**Re: Grading Plan Review
Commercial Development
2020 Walkley Road
Ottawa, Ontario**

As requested, this letter provides a grading plan review for the proposed commercial development located at 2020 Walkley Road in Ottawa, Ontario.

LOCATION WALKLEY CONROY WAREHOUSES 2020 WALKLEY ROAD, CITY OF OTTAWA		PROJECT No. 119067
DRAWING NAME GRADING PLAN PHASE 2 - SOUTH		REV #4 REV #4
DRAWING No. 119067-GR2		PLAN # 18444

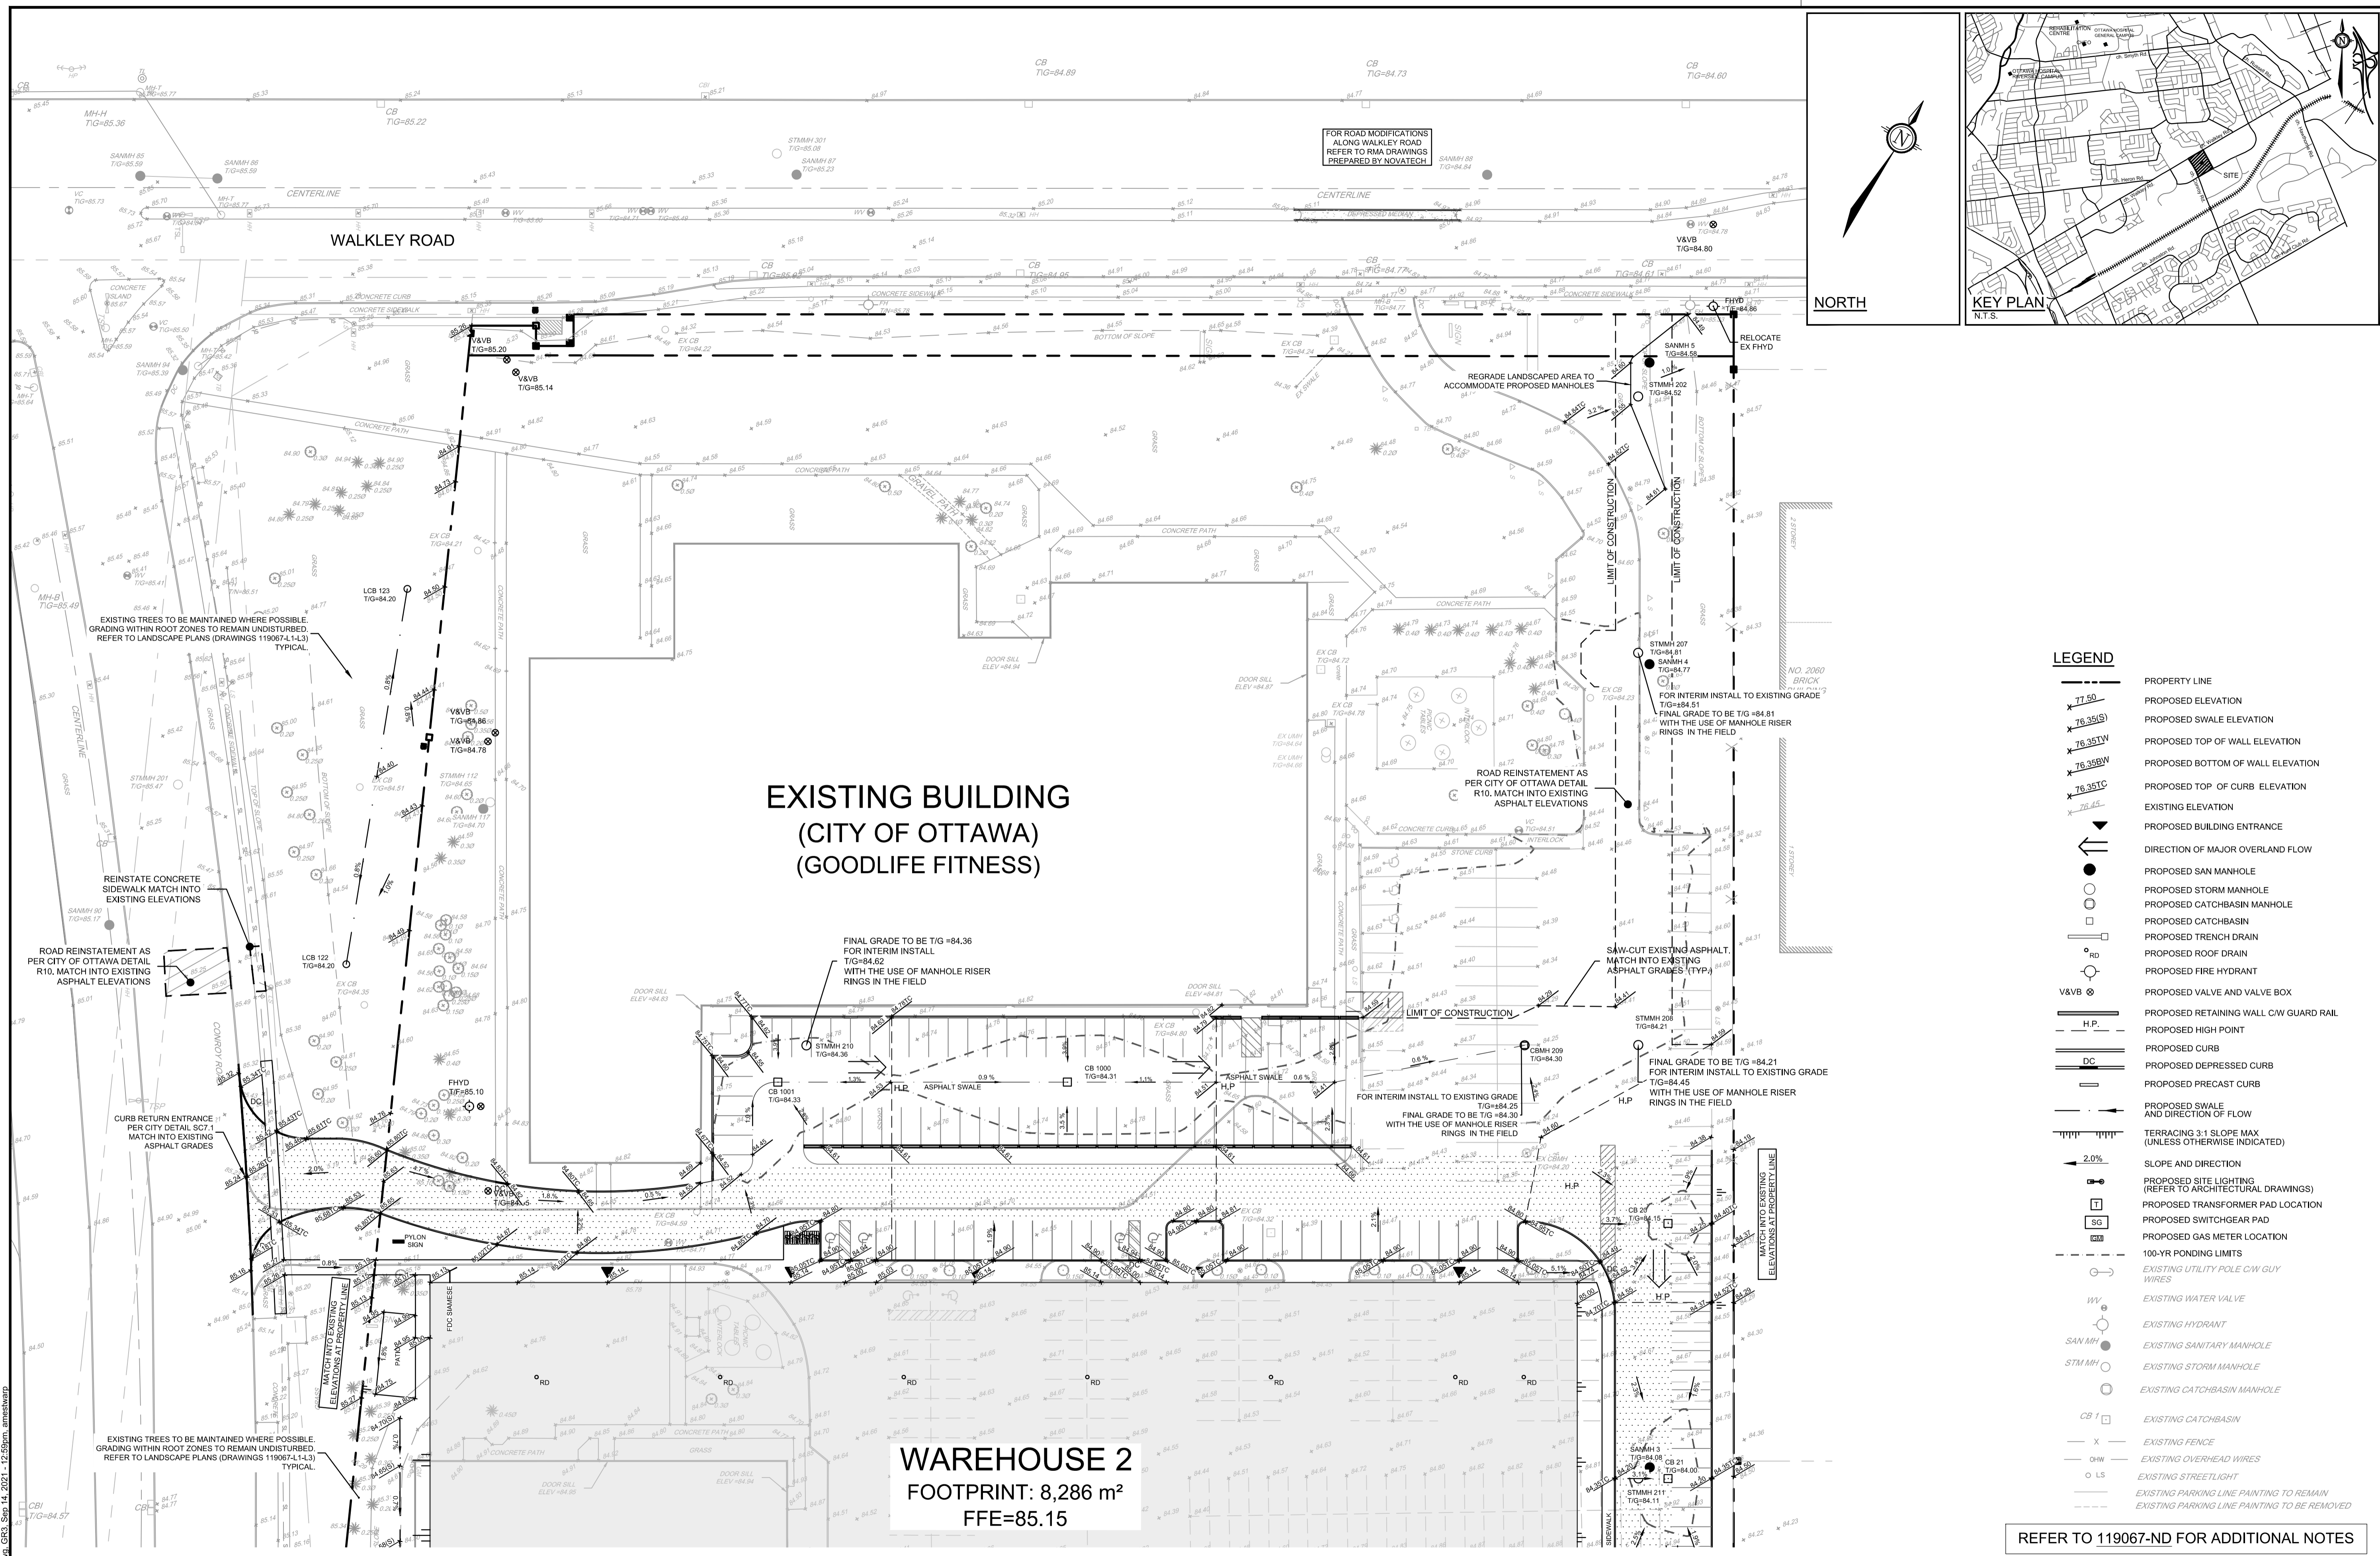
Based on the results of the subsurface investigation, and the finished floor elevations provided by Novatech, the proposed average and maximum grade raise around the warehouses are provided in Table 5.1 below.

Phase/Building Number	Proposed Finished Floor Elevation (metres)	Proposed Average Grade Raise (metres)	Proposed Maximum Grade Raise (metres)
1	85.3	0.6	0.9
2	85.15	1.1	1.2
3	85.3	0.7	1.1

Based on the above, the grades at the north, west, south, and east sides of the warehouses are considered acceptable from a geotechnical point of view.

Warehouse	Original Ground Surface (metres)	Proposed Grade (metres)	Grade Raise or Cut over Original Ground Surface (metres)	Proposed FFE Grade (metres)	Grade Raise at FFE (metres)	Maximum Allowable Grade Raise (metres)	Grade Raise Within Permissible?	Warehouse Specific Notes
1 (North)	84.53	85.15	0.62	85.30	0.77	0.9	Yes	
1 (West)	84.43	85.15	0.72	85.30	0.87	0.9	Yes	
1 (South)	84.53	85.29	0.76	85.30	0.77	0.9	Yes	
1 (East)	84.62	85.20	0.58	85.30	0.68	0.9	Yes	
2 (North)	84.43	85.15	0.72	85.15	0.72	1.2	Yes	
2 (West)	84.30	85.13	0.83	85.15	0.85	1.2	Yes	
2 (South)	83.98	85.13	1.15	85.15	1.17	1.2	Yes	
2 (East)	84.56	85.00	0.44	85.15	0.59	1.2	Yes	
3 (North)	84.54	85.15	0.61	85.30	0.76	1.1	Yes	
3 (West)	84.42	85.00	0.58	85.30	0.88	1.1	Yes	
3 (South)	84.48	85.43	0.95	85.30	0.82	1.1	Yes	
3 (East)	84.38	85.25	0.87	85.30	0.92	1.1	Yes
